Subject: North of Summer Lane, Pagham P/70/19/RES & P/29/21/DOC

Simon J Davis MRTPI
Principal Planning Officer
Directorate of Place

PROJECT SUMMER LANE, PAGHAM				CLIENT HANBURY PROPERTIES LTD	
DRAWING TITLE SECTION 278 HIGHWAY WORKS				vectos. 4th Floor Oxford Place, 61 Oxford Street, Manchester, M1 6EQ	
DRAWN AM	CHECKED PW	DATE 16.02.2021	SCALE AT A1 1:200	DRAWING NUMBER VD16396-ID-SK-0005	REVISION A

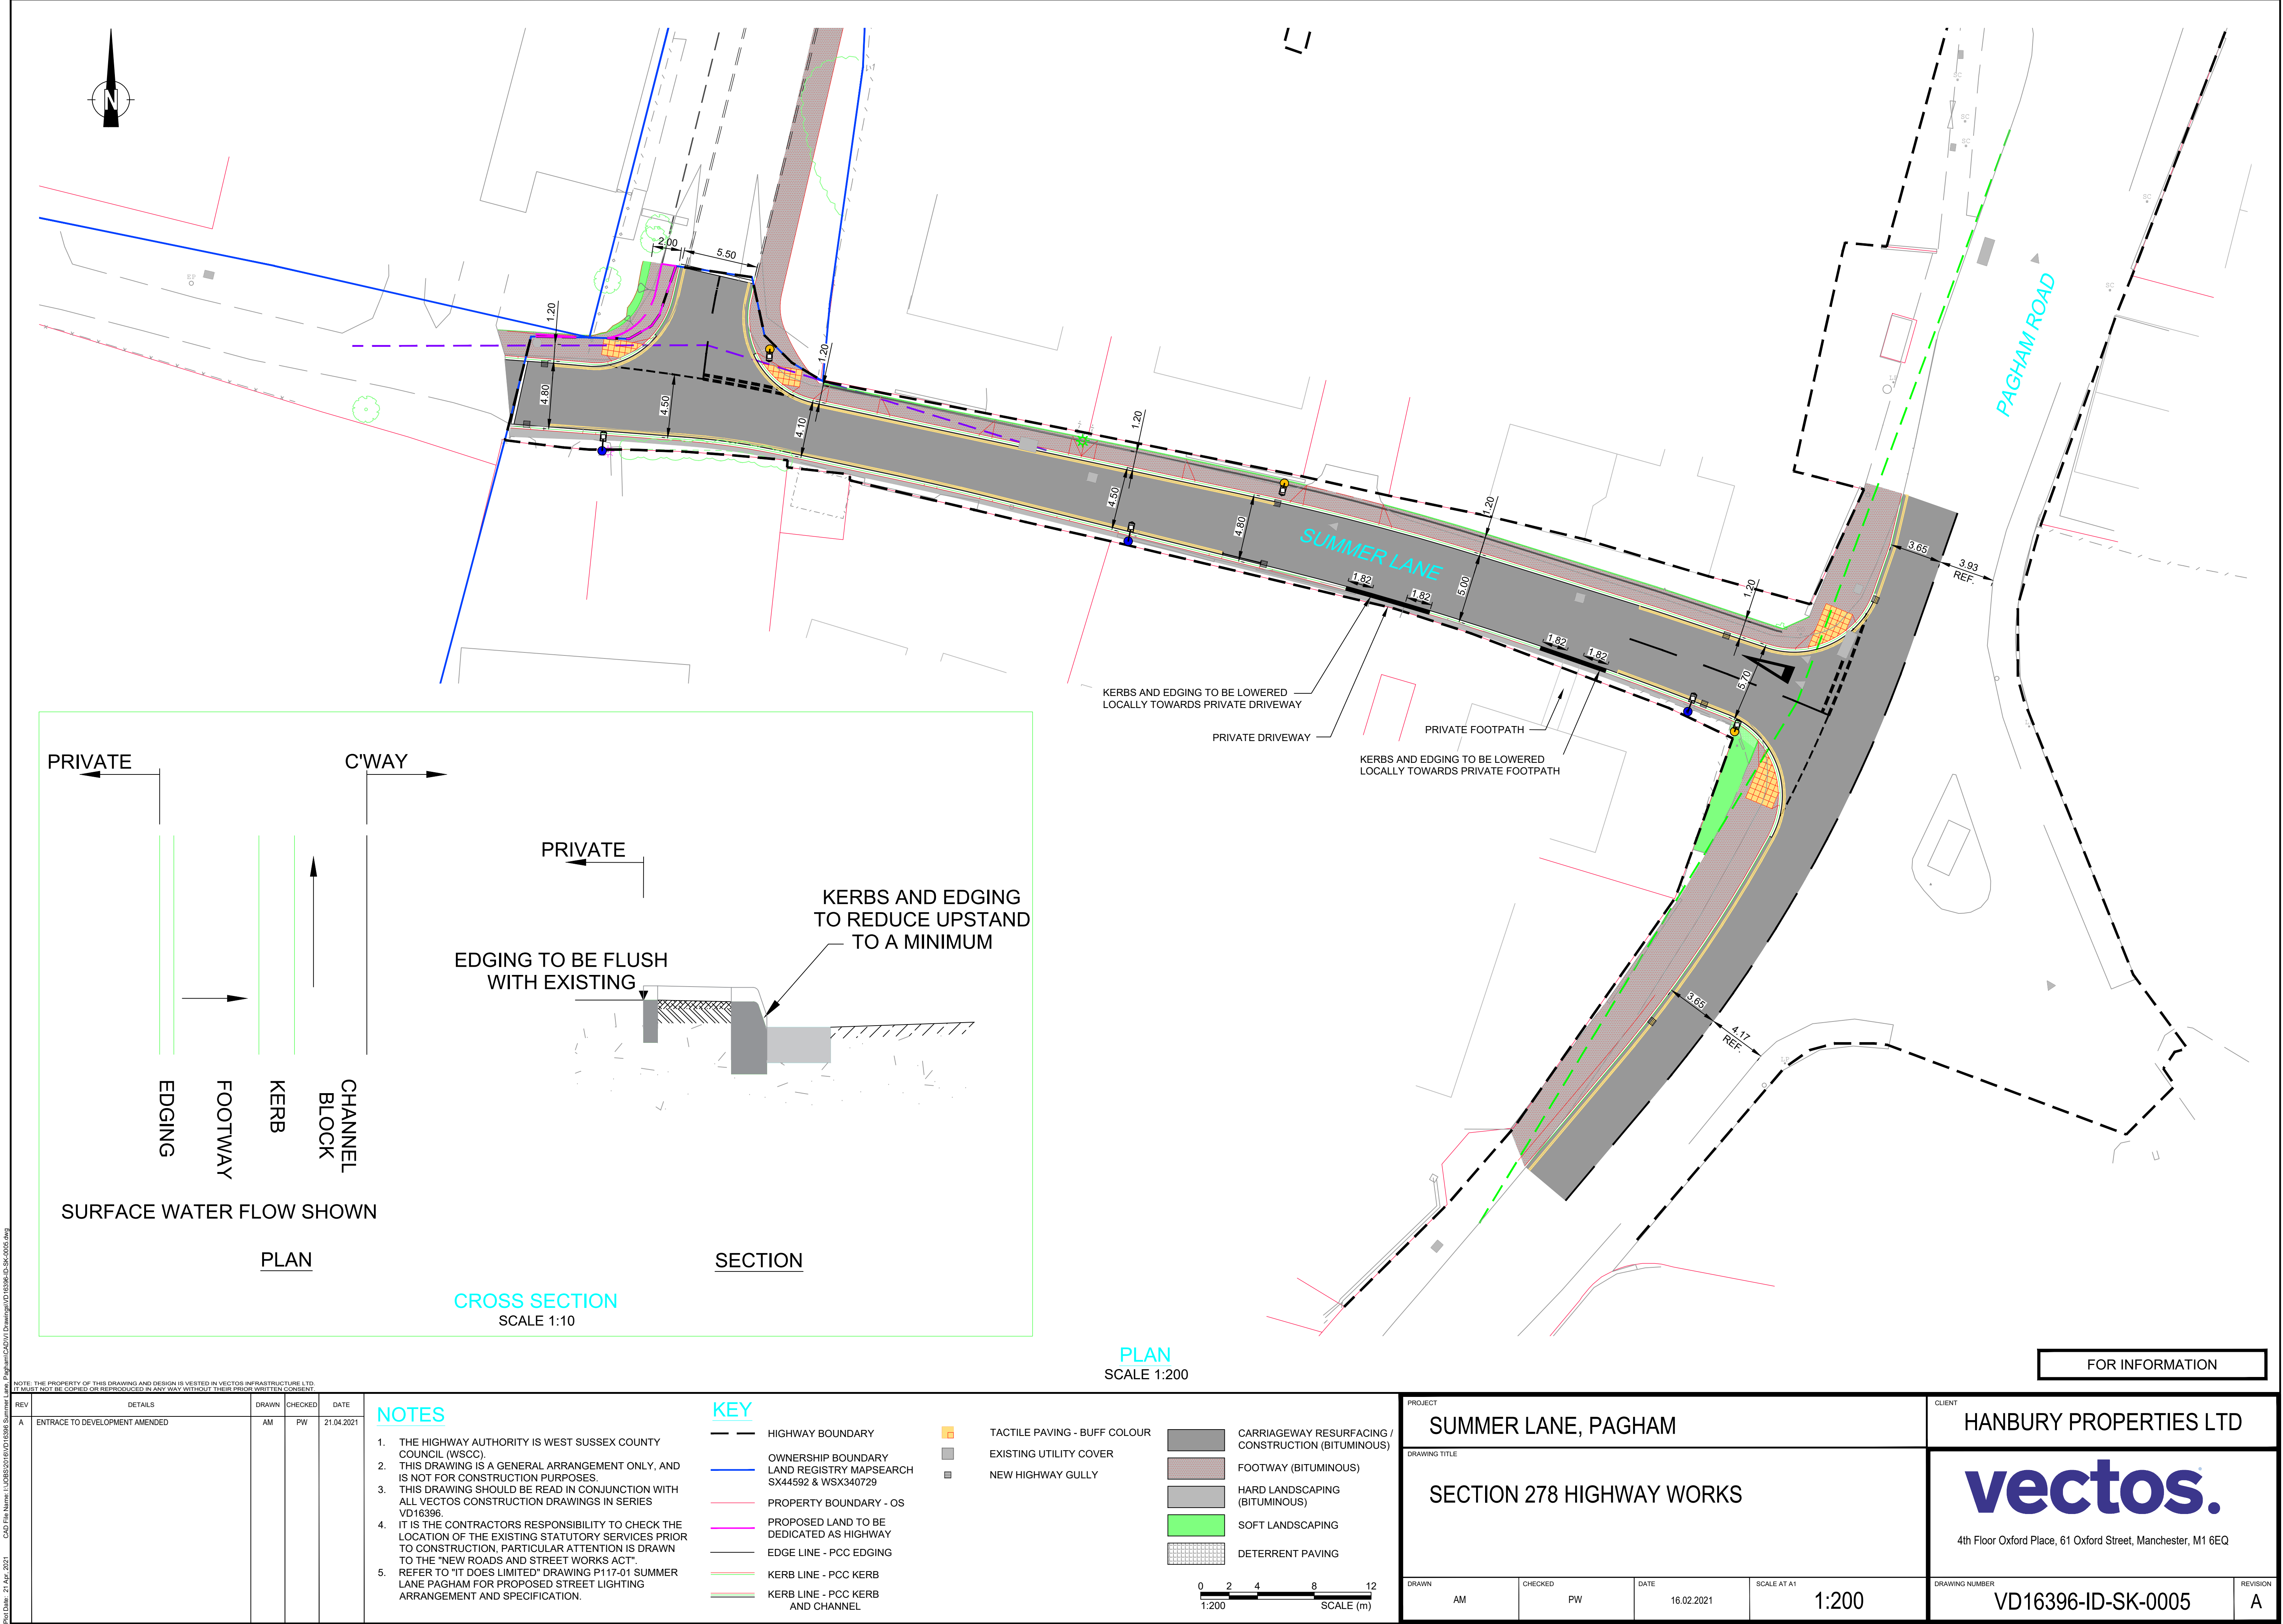
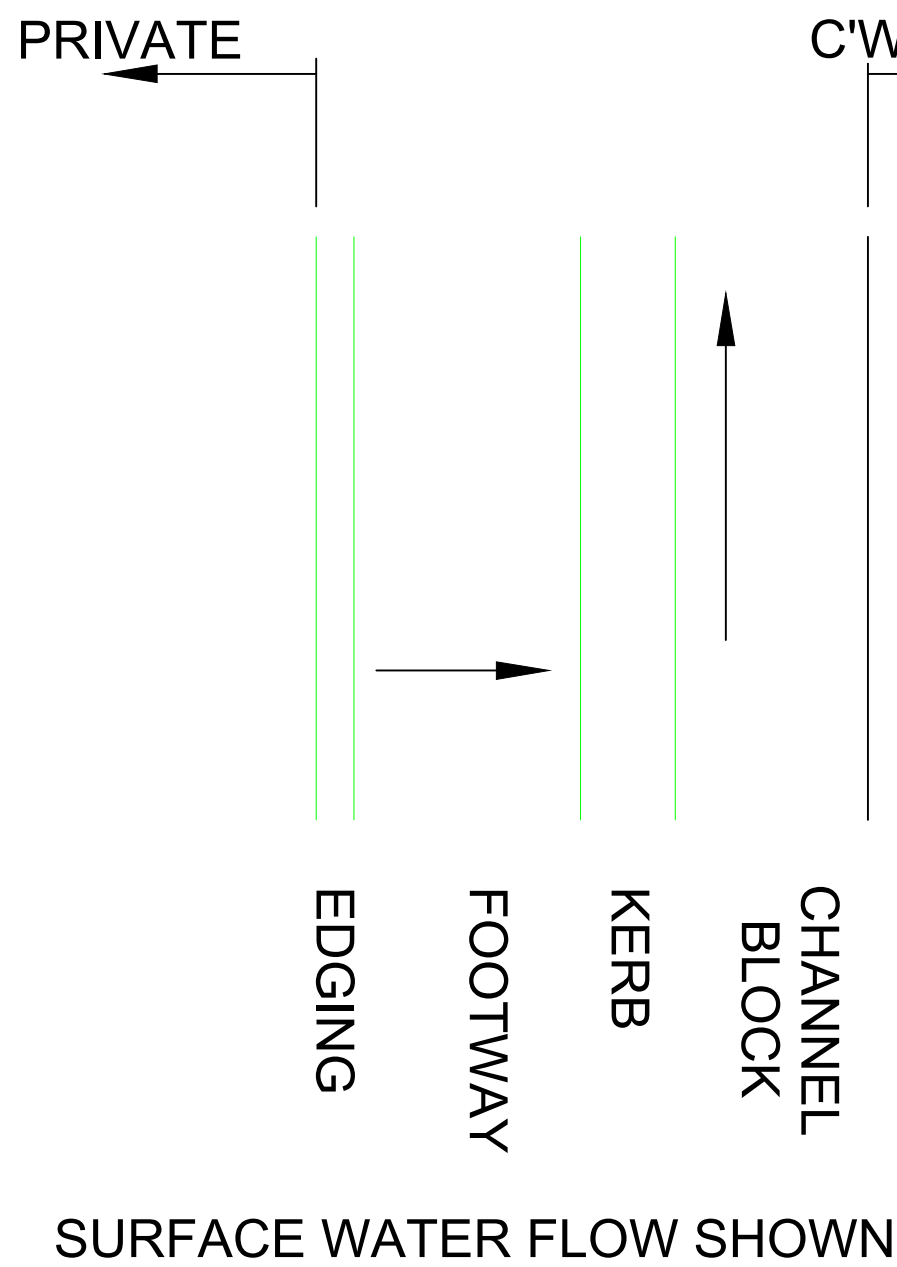
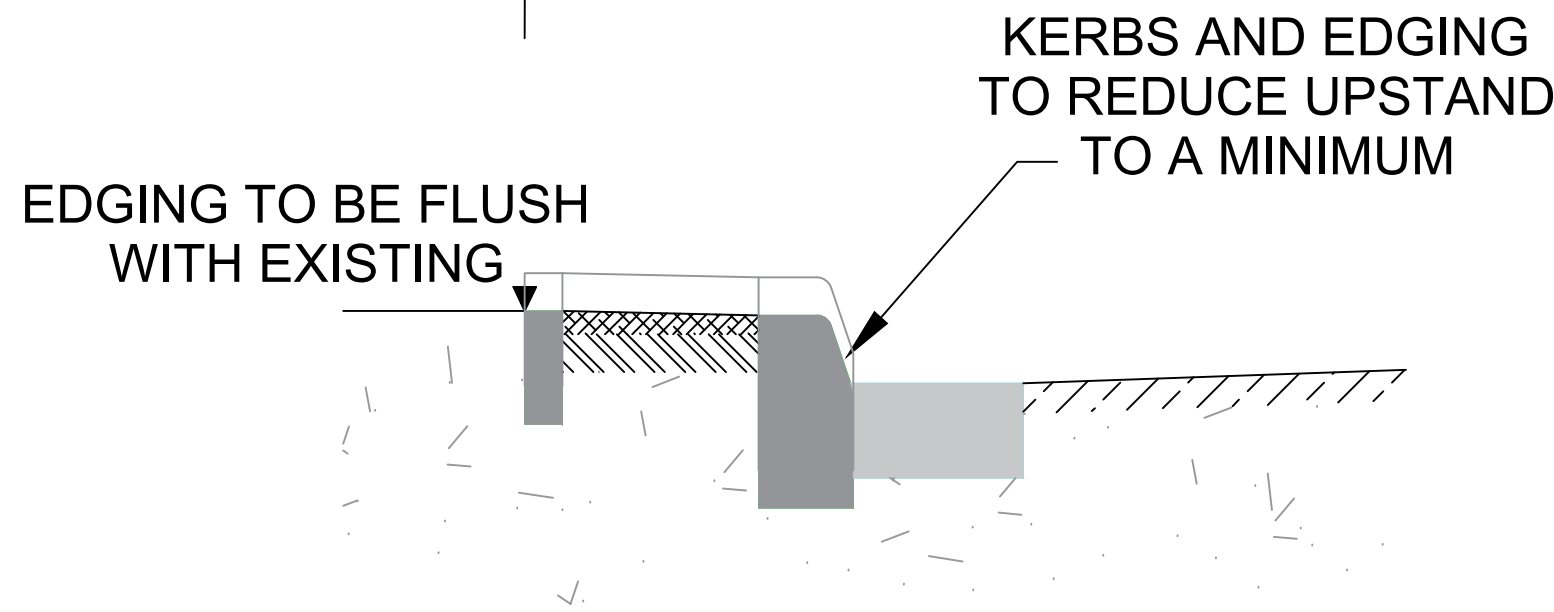
Separately, I am aware of recent concerns expressed in relation to P/29/21/DOC which you can see on our website. It has been stated that the access being constructed on the ground (assumed to be the access to the eastern parcel) is not in accordance with the access plan approved under P/58/15 OUT, the access plan approved under P/70/19 RES or that shown on the drawing submitted under P/29/21/DOC. The only obvious issue I can see from comparing the plans is that the s.278 drawing no longer shows any pavement

on the eastern side but then I haven't seen the access on site. Please can you look into this and comment please.
